Rezoning Transportation Analysis

Petition Number: 2020-007

General Location Identifier: Tax ID 11123334

Date	Description
03-24-2020	First Review

ERWIN CAPITAL/BEAVER FARMS TECHNICAL DATA SHEET

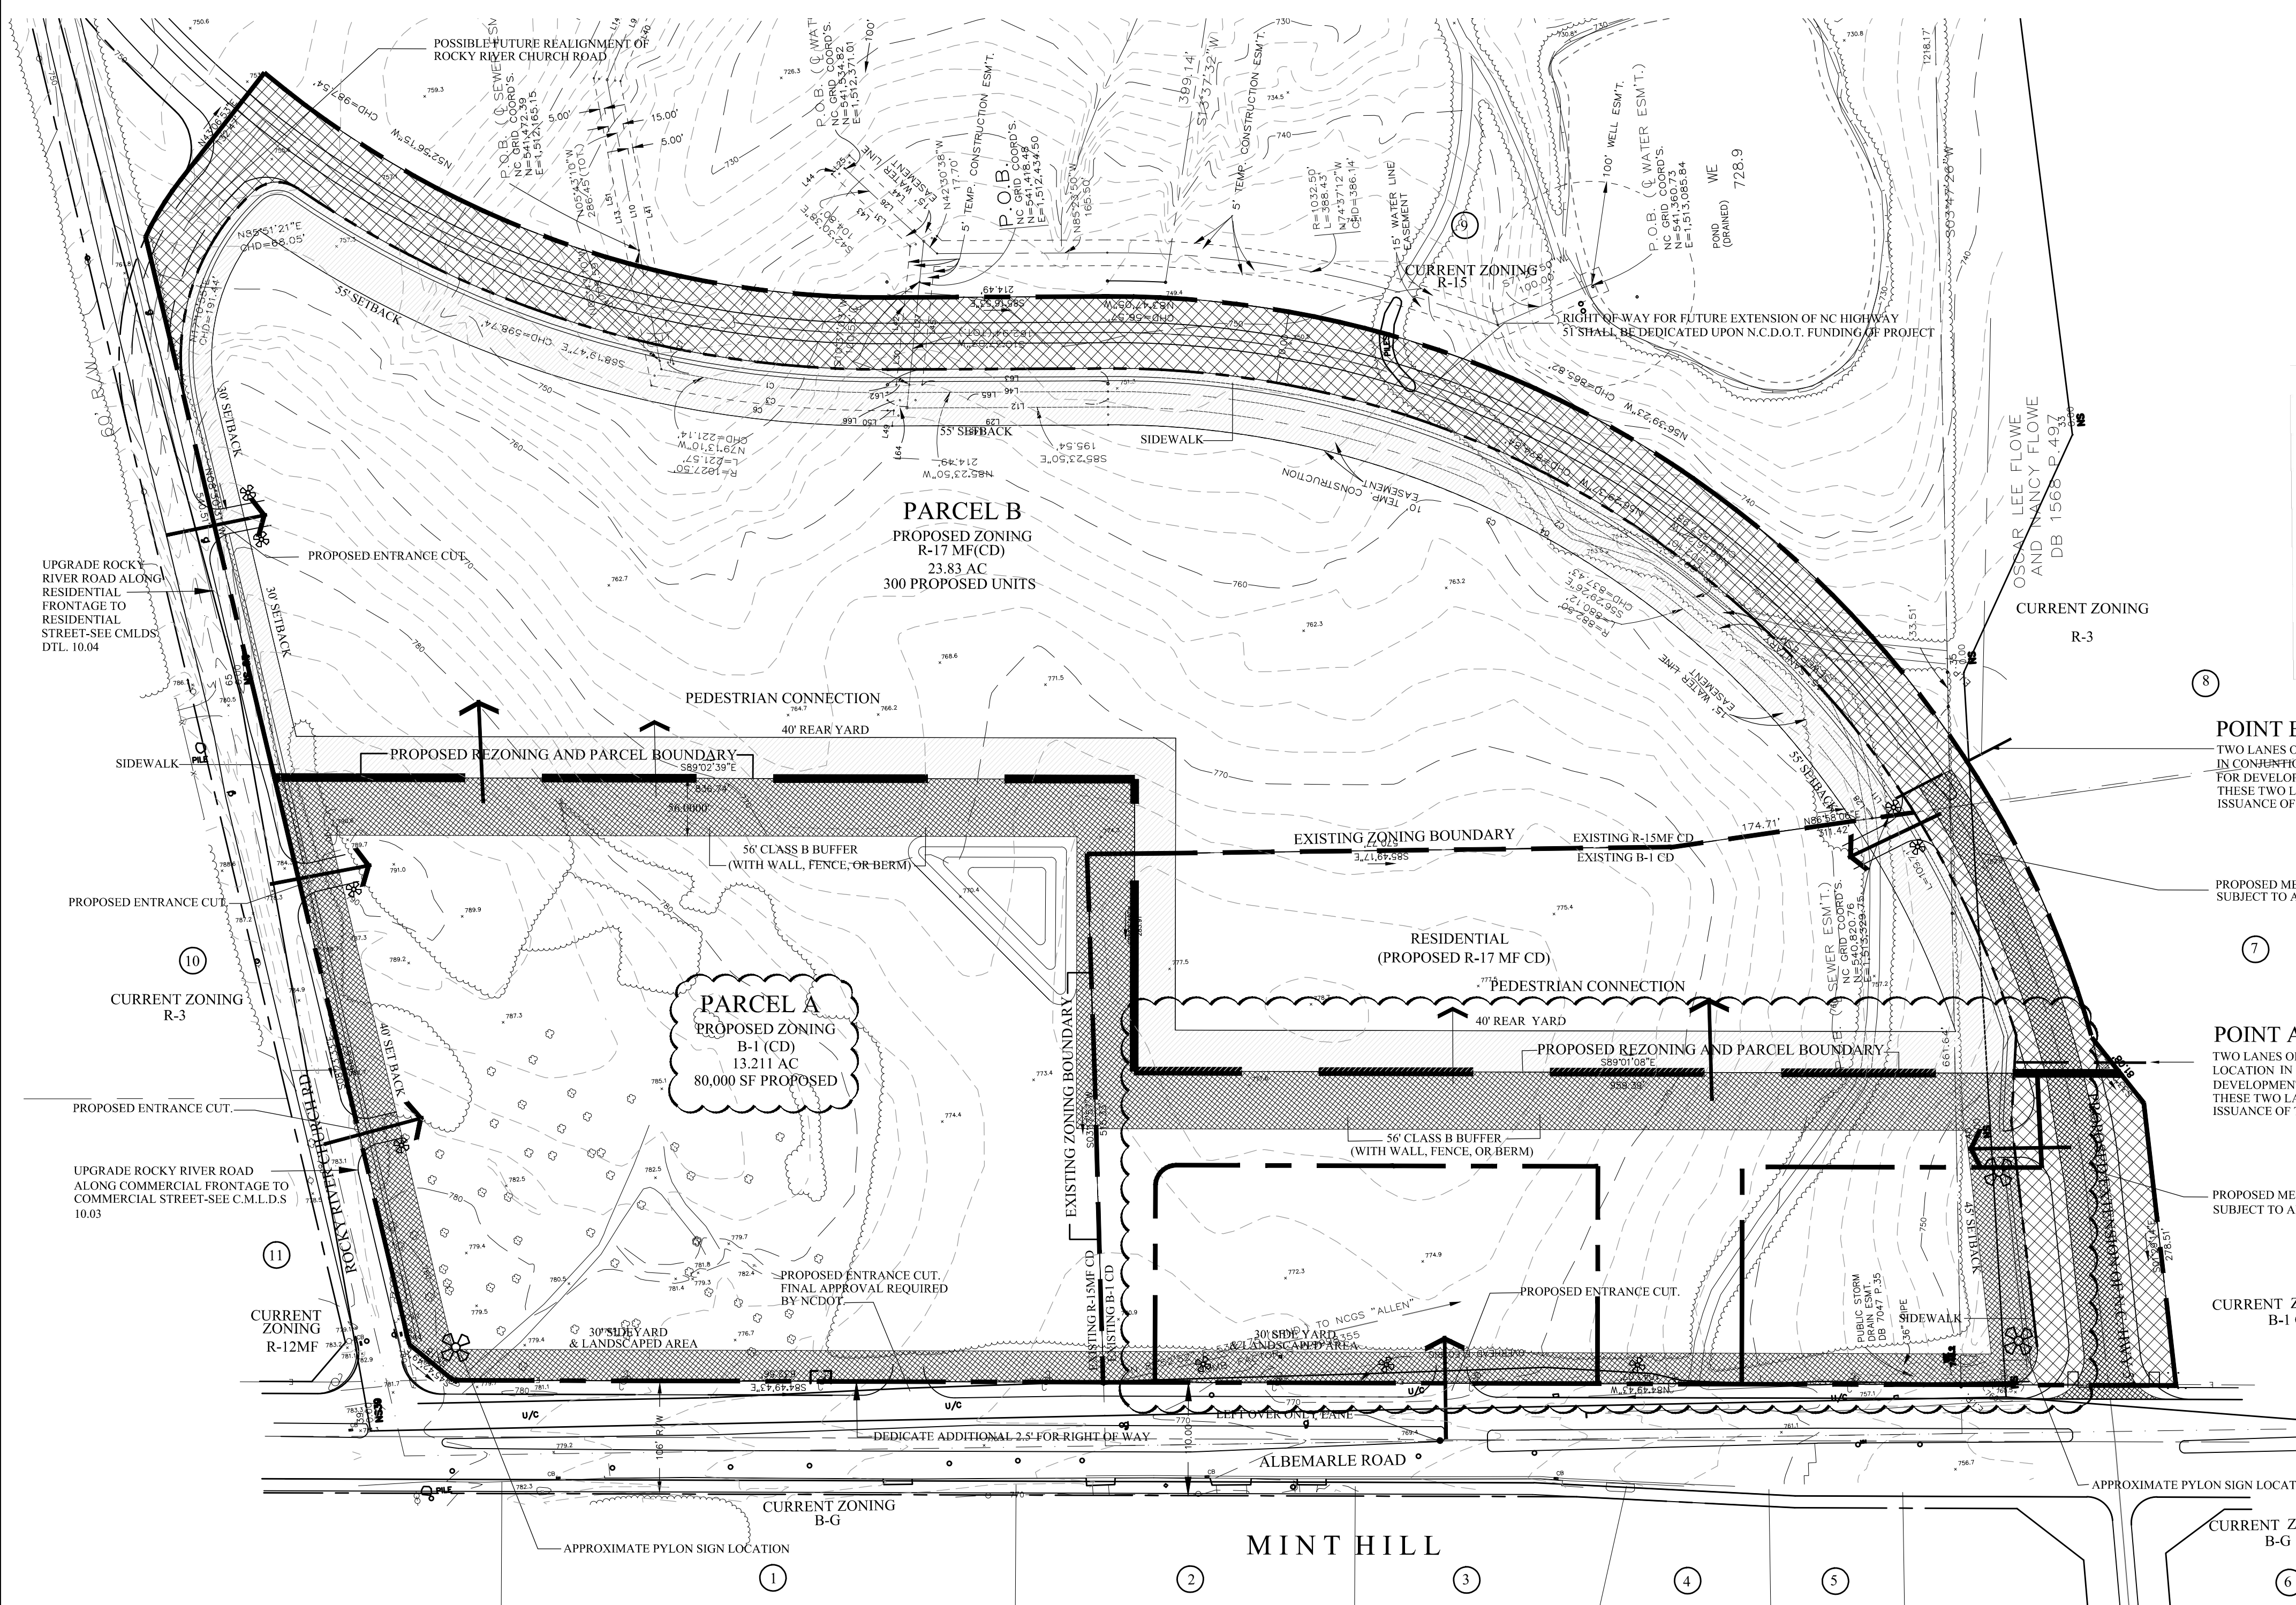
1. **Curblin** The proposed zoning district has a setback measured from back of the existing or proposed future curblin.
 - a. **Albemarle Road:** The site plan reflects the future location of curb and gutter.
 - b. **Rocky River Church Road Name:** The future location of curb and gutter is in its existing location.
 - c. **Woodland Beaver Road:** The future location of curb and gutter is in its existing location.

The site plan should show the curb and gutter labeled and dimensioned from the centerline for each road.

3. The petitioner should revise the site plan and conditional note(s) to commit to dedicate a minimum of 50 feet of right-of-way from the Albermarle Road centerline, per Chapter 12 of the Zoning Ordinance requirements for a Charlotte Regional Transportation Planning Organization (CRTPO) classified major thoroughfare. The site plan should label and dimension the right-of-way from the road centerline.

4. We request the petitioner to revise the site plan and conditional note(s) to commit to constructing an 8' planting strip and a 12' multi-use path along Albermarle Road and Rocky River Church Road.

5. The petitioner should revise the site plan and conditional note(s) to include two ADA curb ramps at each curb return.
6. The petitioner should revise the site plan to add a note specifying dedication and fee simple conveyance of all rights of way to the City before the site's first building certificate of occupancy is issued. CDOT requests right of way set at 2' behind back of sidewalk where feasible.
7. The petitioner should revise the site plan to add a note specifying all transportation improvements will be approved and constructed before the site's first building certificate of occupancy is issued. The petitioner may phase transportation improvements if said improvements and phasing are explicitly described in site plan notes.
